Subject: RE: Planning Consultation on: P/88/22/DOC

Application No: P/88/22/DOC
Registered: 24th May 2022
Site Address: Land North of Sefter Road & 80 Rose Green Road Pagham
Description of Works: Approval of details reserved by condition imposed under P/134/16/OUT relating to conditions 10-surface water drainage, 12-maintenance and management of surface water drainage system, 14-foul drainage system, 16-external lighting, 17-Construction Management Plan, 22-setting out when roads, footpaths, cycleways and emergency routes are to be constructed, 26-street lighting and 28 (part)-energy conservation and renewable energy.

North of Sefter Road, Pagham – P/88/22/DOC Comments Tracker				Initial Issue Date: 12-10-2022 Issue Date: - Revision 1.0	
	ADC Drainage Comments 11-10-22	Applicants Response	ADC Drainage Comments 18-11-22	Applicants Response	ADC Drainage Comments 25-01-23
I hereby confirm the surface water drainage design and maintenance manual is satisfactory and recommend 'part' discharge of conditions 10 & 12.					
	Initial/Planning:

Drawing Number	Rev.
10768/1810	P8

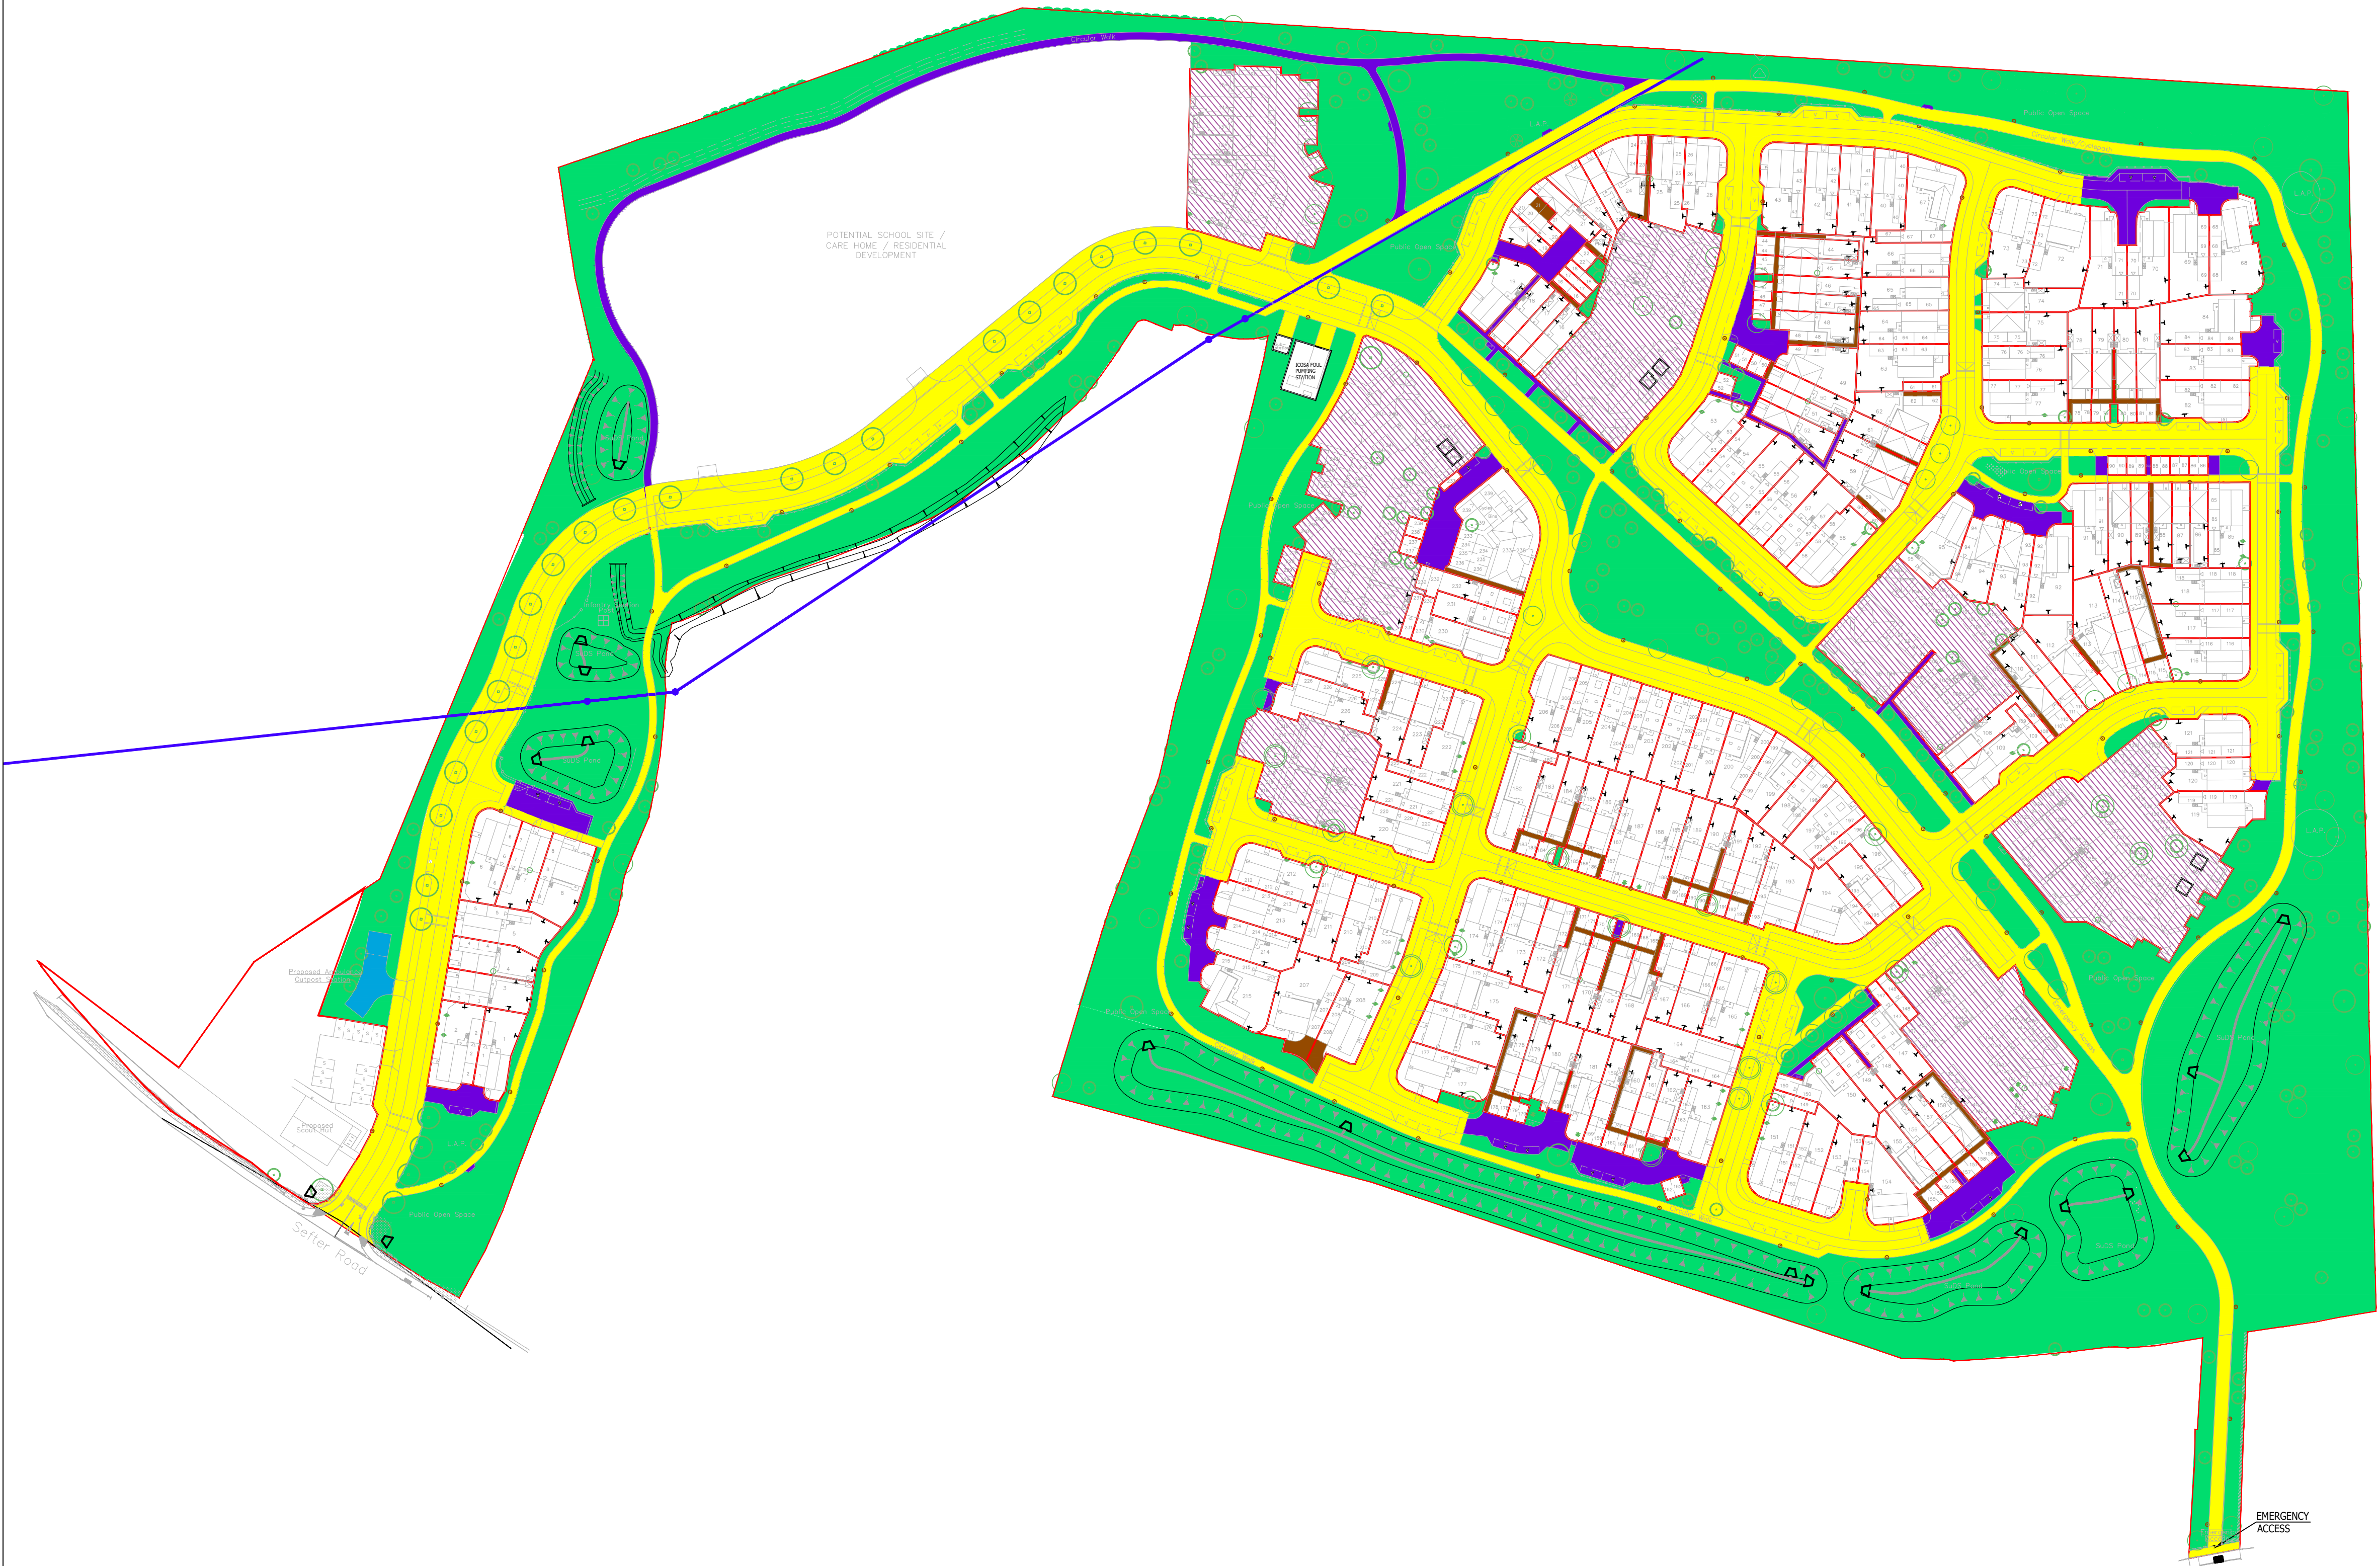
39.	Please advise if ICOSA are adopting the SW basins and if these comply with their design criteria/policy, in addition to DCG.	Icosa Water will not adopt attenuation ponds	Noted, with reference to conveyance drawing 1810 these area re to be ‘privately managed land’. Please provide details of the management company arrangement in due course.	To follow	Noted to follow.

Drawing Number			
10768/1605			
Rev			
P7

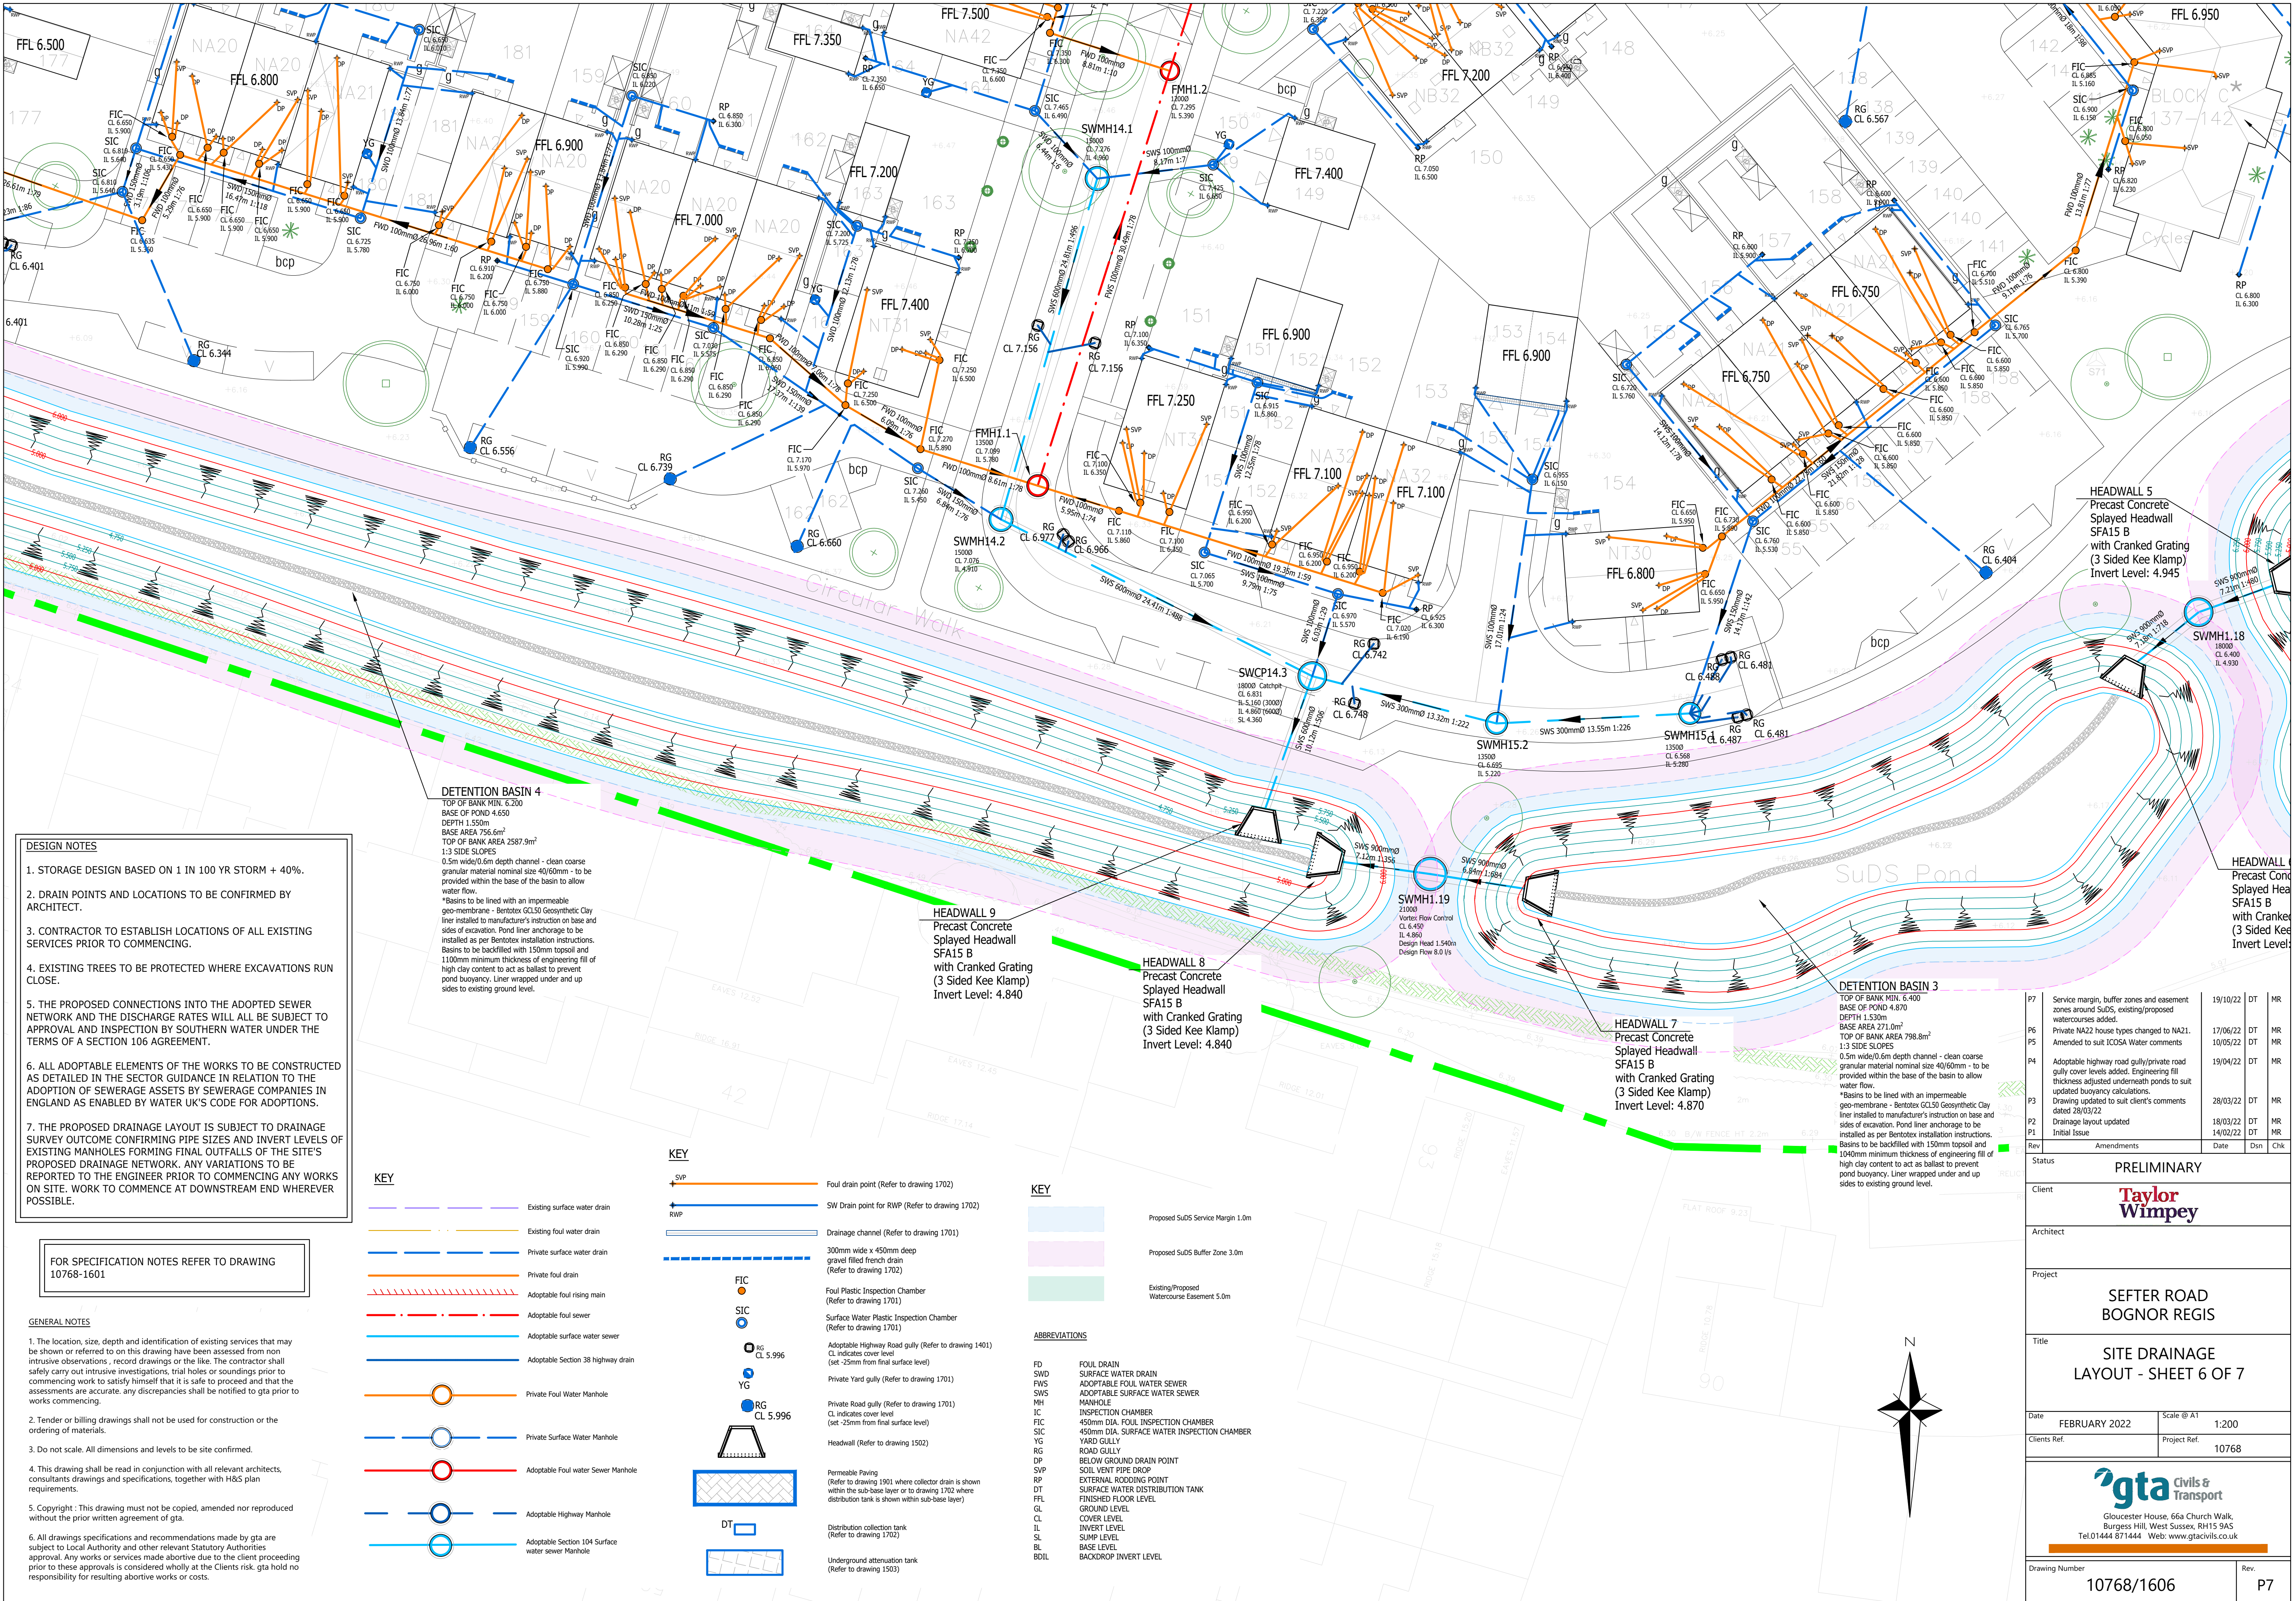
8.	Engineering drawing must show 3.0m buffer zones from all SuDS features & the anti-tank ditch route.	Buffer zone hatched areas added on drawings 10768/1601-1607.	Agreed and closed.	-

9.	Engineering drawing must show 5.0m easement zones from all ordinary watercourses. The existing watercourses are on the topographical survey, however are not clear; suggest these are subtly hatched to stand out.	Easement zones added on drawings 10768/1601-1607	Noted, however the existing ditch corridors are very faint on the pdf's. please can these be enhanced. (See note 7 above)	Noted, the hatch on these have been amended, see enclosed latest plans.	Noted and Closed.

11.	There should be at least a 1.0m service margin (max 1:20 slope) between the edge of footpaths and all SW basins top of bank. Basins 1, 4, 5, 6 may be affected.	Service margin added on drawings 10768/1601-1607. Maintenance of SuDs features does not form an issue.	Path 351 is very close to SW basin 5 top of bank. Drawing 1822/P7 illustrates the northmost level difference exceeds 600mm height or worse. Drawing 1634, section K-K does not identify this. This does not comply as commented previously. The path surface level alongside SW basin 6 is at 5.6m close to the top of bank being 5.35m.	Looking at this we now think that there is insufficient space to fit in a pond basin here with 3m buffer zone, since we cannot move the path as it is on the agreed planning layout. Changing the pond shape makes the pond outfall not possible or the pond too shallow. Therefore, this pond has been substituted for a tank as now shown on the enclosed plan.	Noted and Closed. Where this basin may have formed part of earlier planning layouts, an NMA may be required.

23.	Proposed fence/gate post sit above 600mm diameter culvert just north of SWCP17.8; foundation may conflict with culvert which has reduced cover.	Post adjusted. Contractor to ensure fence foundation spans either side of culvert note added on drawings 10768/1601-1607	Agreed and closed.	-

47.	Engineering plans to denote footprint areas for porous paving and SW basins to correlate with calculations.	Drawings 10768/1601-1607 updated	Noted, however it is not clear where the SW basin areas are tallied.	Please refer to Drg 1611 which shows the areas of the basins and permeable paving with associated pipe numbers. This correlates with the MD calculations.	Noted and Closed.
